**Addendum No. 2**

RE: Contract # C204096

**Guilford County (U-2525C)**

Greensboro Eastern Loop From US-29 North Of Greensboro

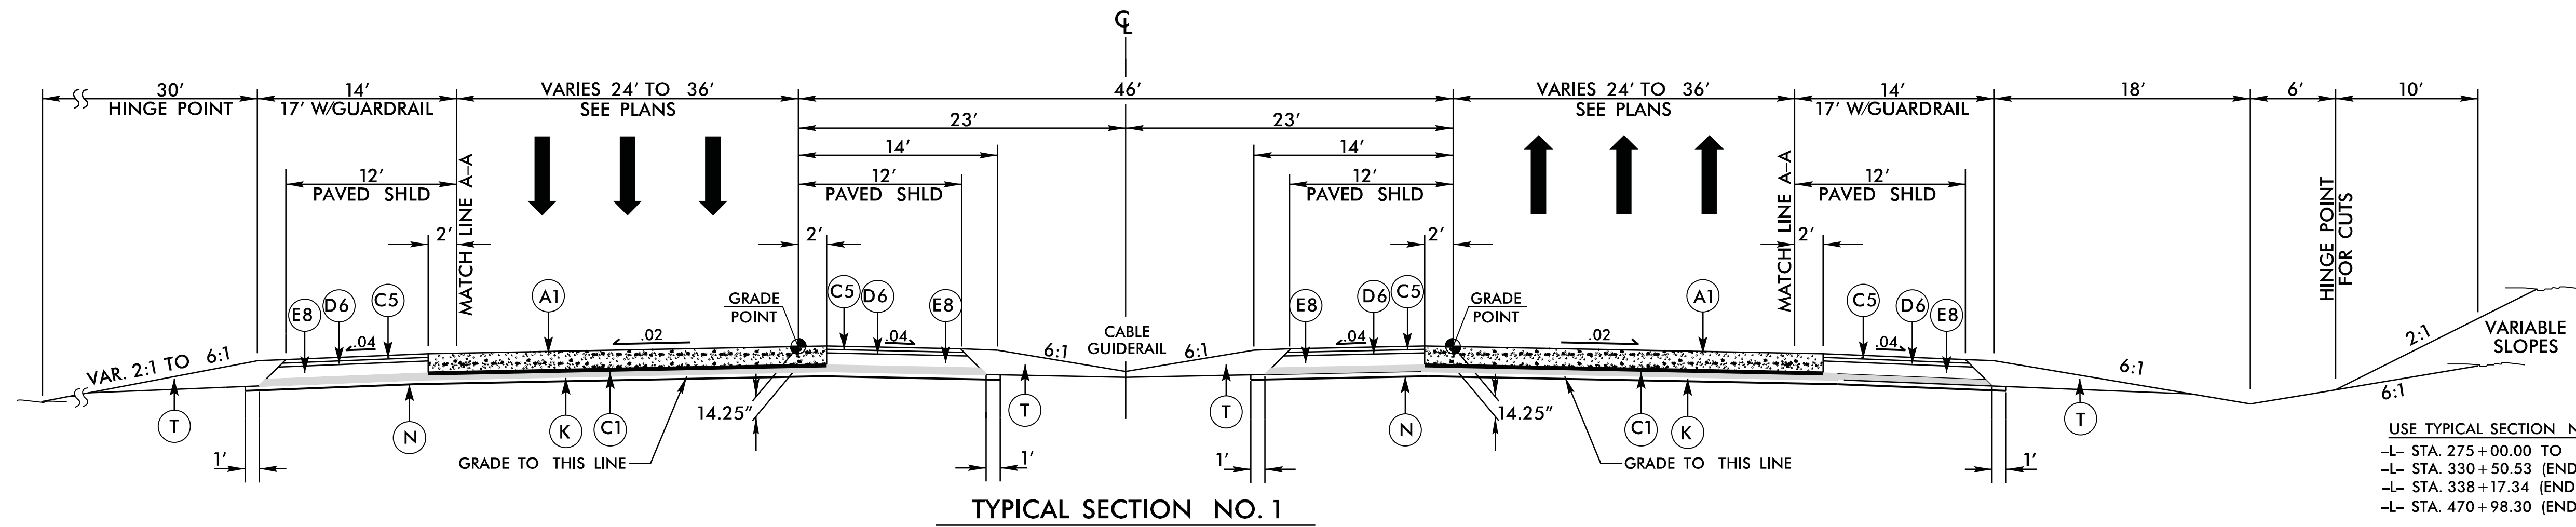
Sheet No.	Revisions
2A-1	Revised to add Note 2 to address the paving limits onto adjacent project U-2524D
